Arun District Council
Development Control
Arun Civic Centre
Maltravers Road
Littlehampton
West Sussex
BN17 5LF

Our ref: HA/2022/123981/03-L01

Your ref: BN/11/22/OUT

AMENDED MODEL REVIEW- OUTLINE APPLICATION WITH ALL MATTERS RESERVED (EXCEPT FOR THE A29 REALIGNMENT) FOR THE DEMOLITION OF EXISTING STRUCTURES AND MIXED USE DEVELOPMENT TO PROVIDE RESIDENTIAL DWELLINGS (USE CLASS C3), CARE HOME/SENIOR LIVING ACCOMMODATION (USE CLASS E/F2/SUI GENERIS), A PRIMARY SCHOOL PLUS OPEN SPACE, LANDSCAPING, DRAINAGE AND ALL OTHER ASSOCIATED ANCILLARY WORKS; AND REALIGNMENT OF THE A29 AND EARLY CONNECTION TO EXISTING A29 INCLUDING CONSTRUCTION OF A NEW ROAD CARRIAGEWAY, JUNCTIONS AND ASSOCIATED INFRASTRUCTURE. THIS APPLICATION ALSO LIES WITHIN THE PARISH OF ALDINGBOURNE, AFFECTS THE SETTING OF LISTED BUILDINGS, AFFECTS THE CHARACTER & APPEARANCE OF THE EASTERGATE CHURCH LANE CONSERVATION AREA AND AFFECTS A PUBLIC RIGHT OF WAY. THIS APPLICATION IS THE SUBJECT OF AN ENVIRONMENTAL STATEMENT. BARNHAM, EASTERGATE, WESTERGATE BEW PARCEL SC1 BARNHAM

Appendix A – General Arrangement for 200m Multi-Span Option

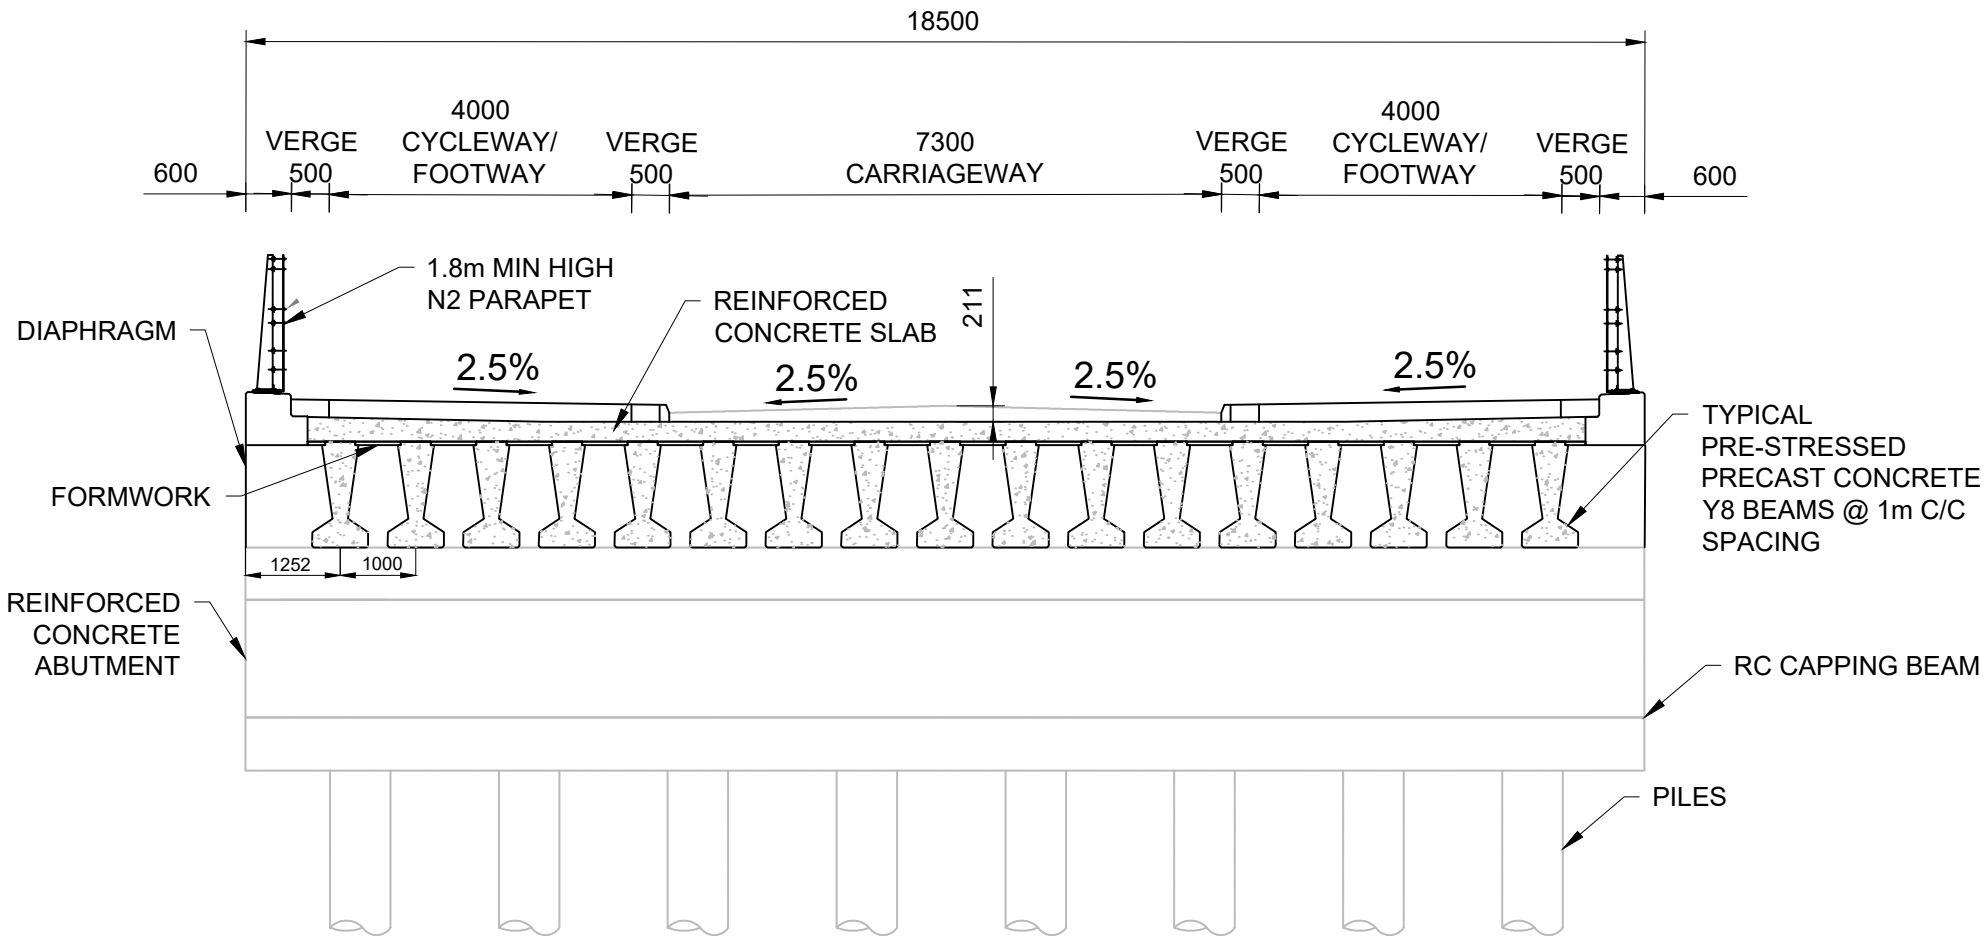
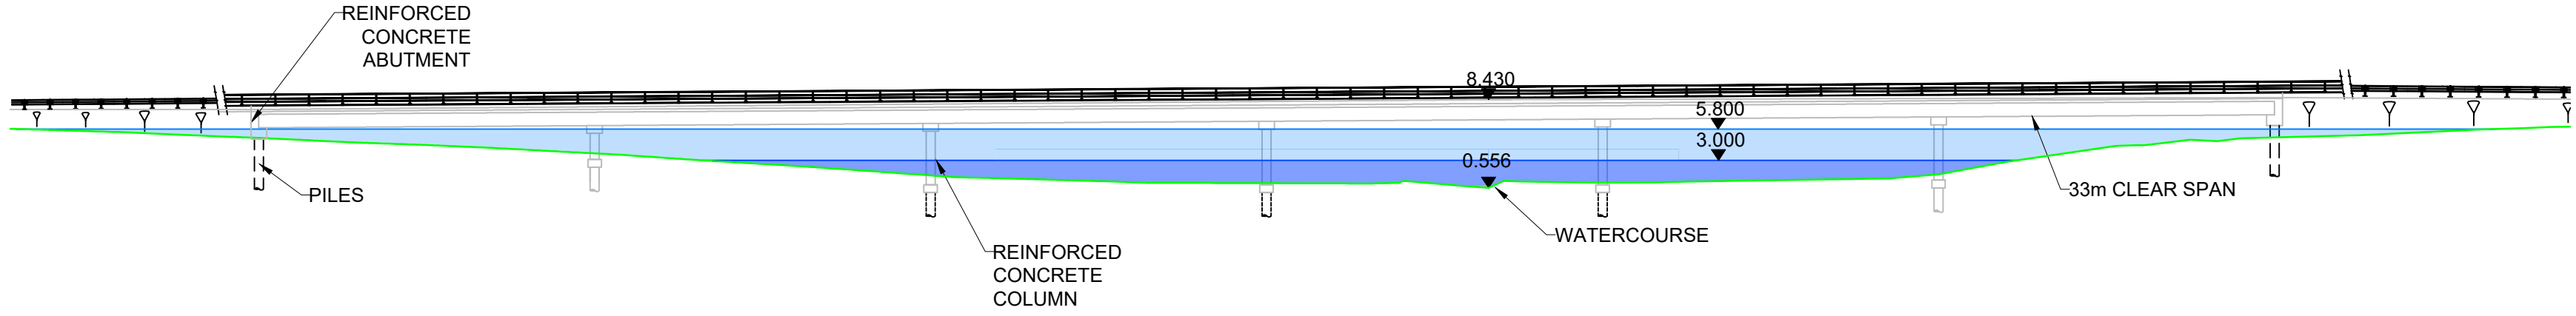
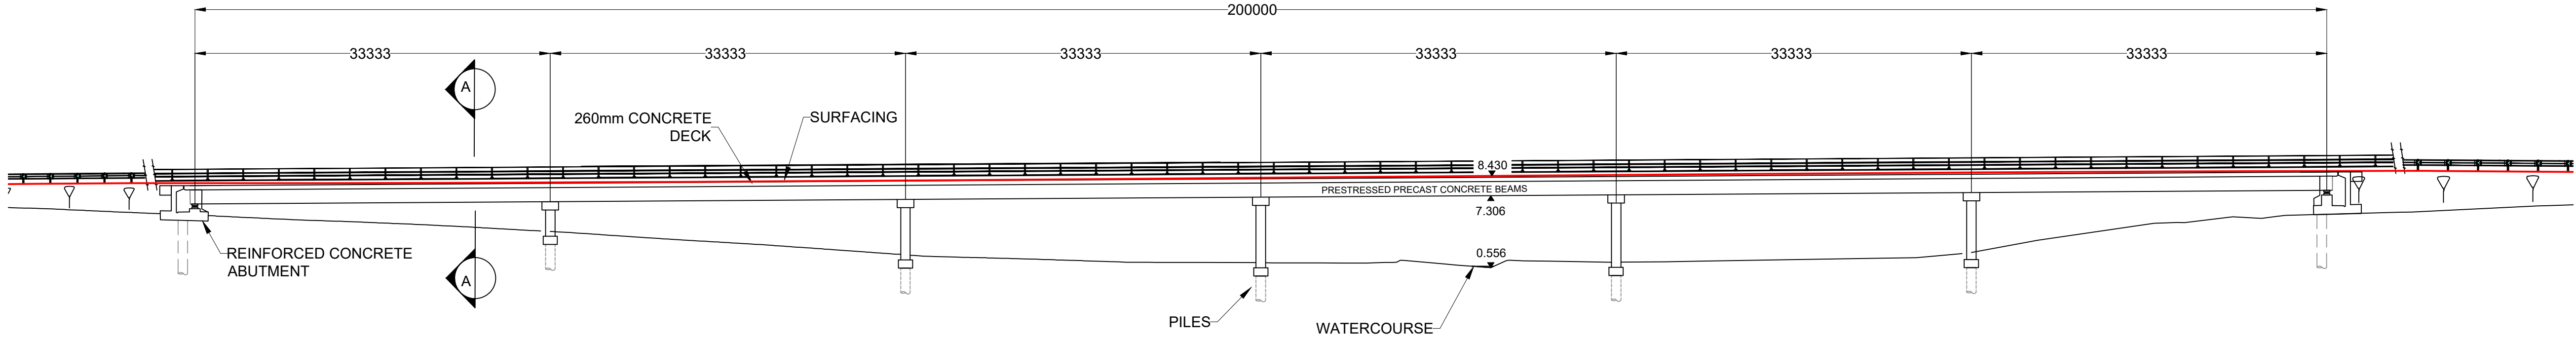
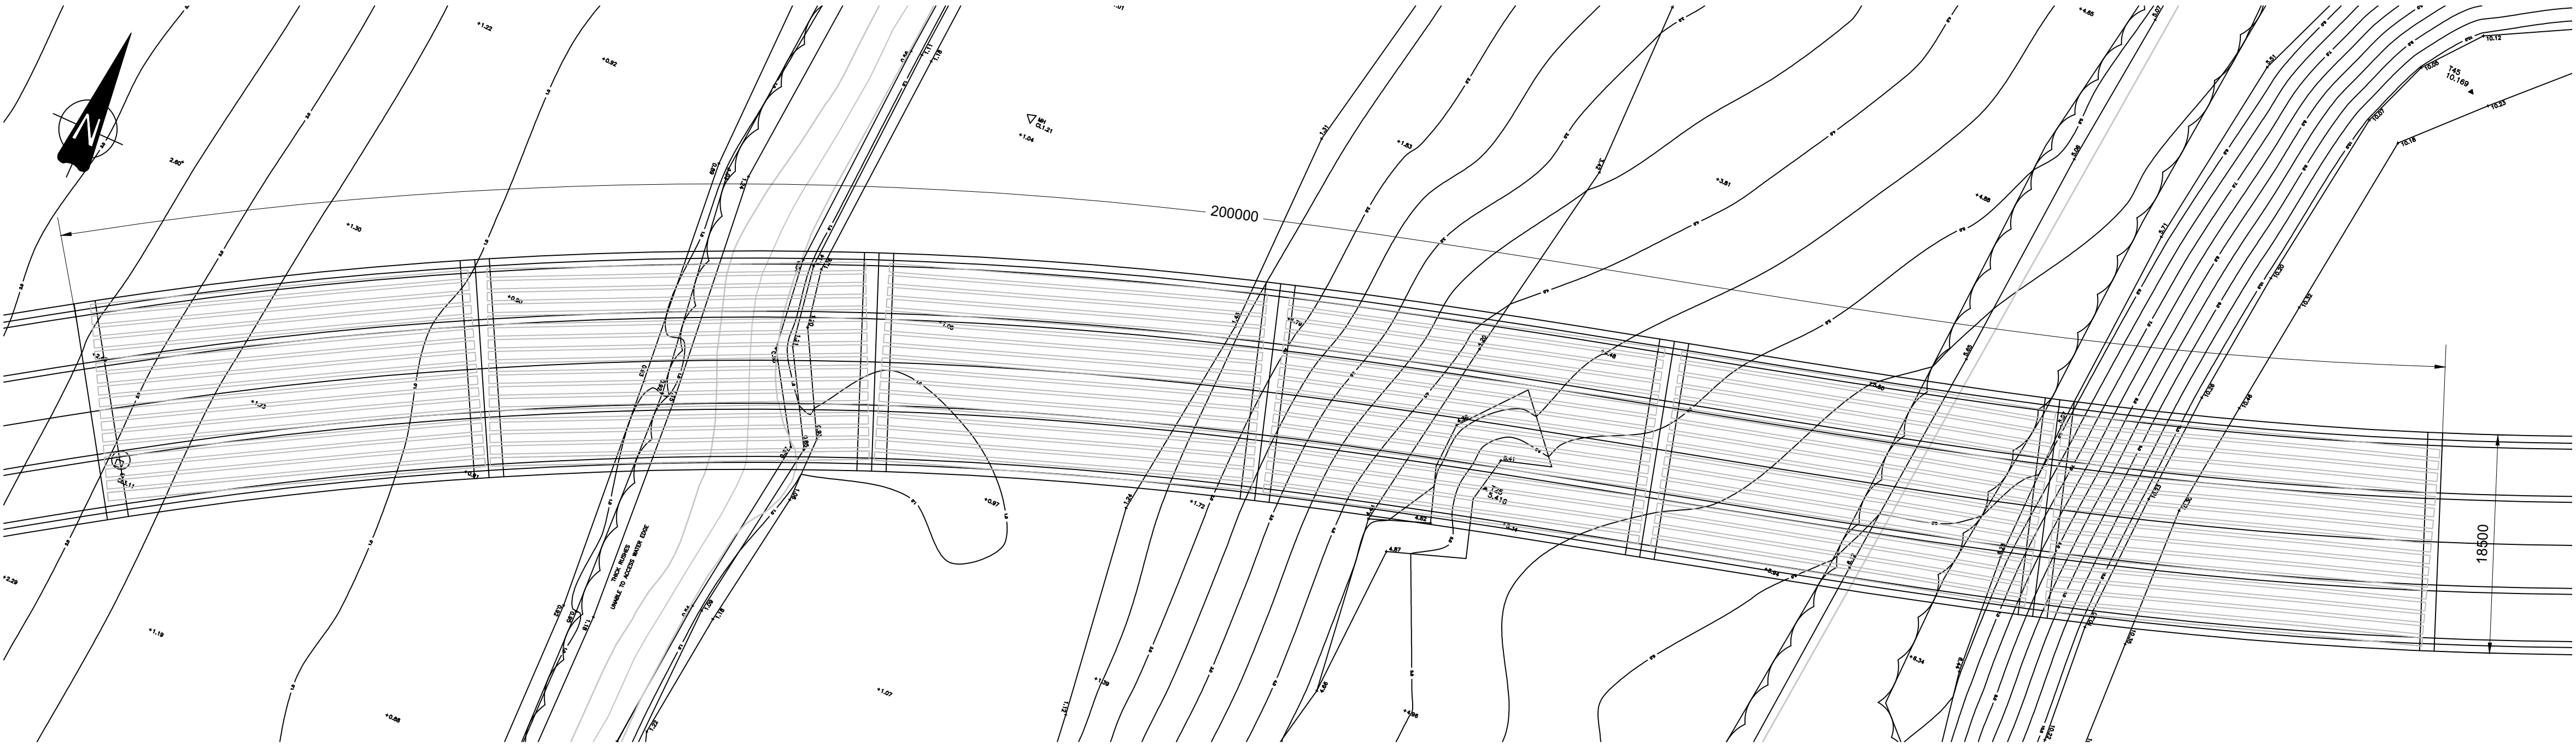
We would again highlight our preference for the 200m multi-span option from a flood risk perspective but would note that this would also require flood plain compensation for the bridge piers. This would need to be evidenced and we would again expect the applicant to review the risk.
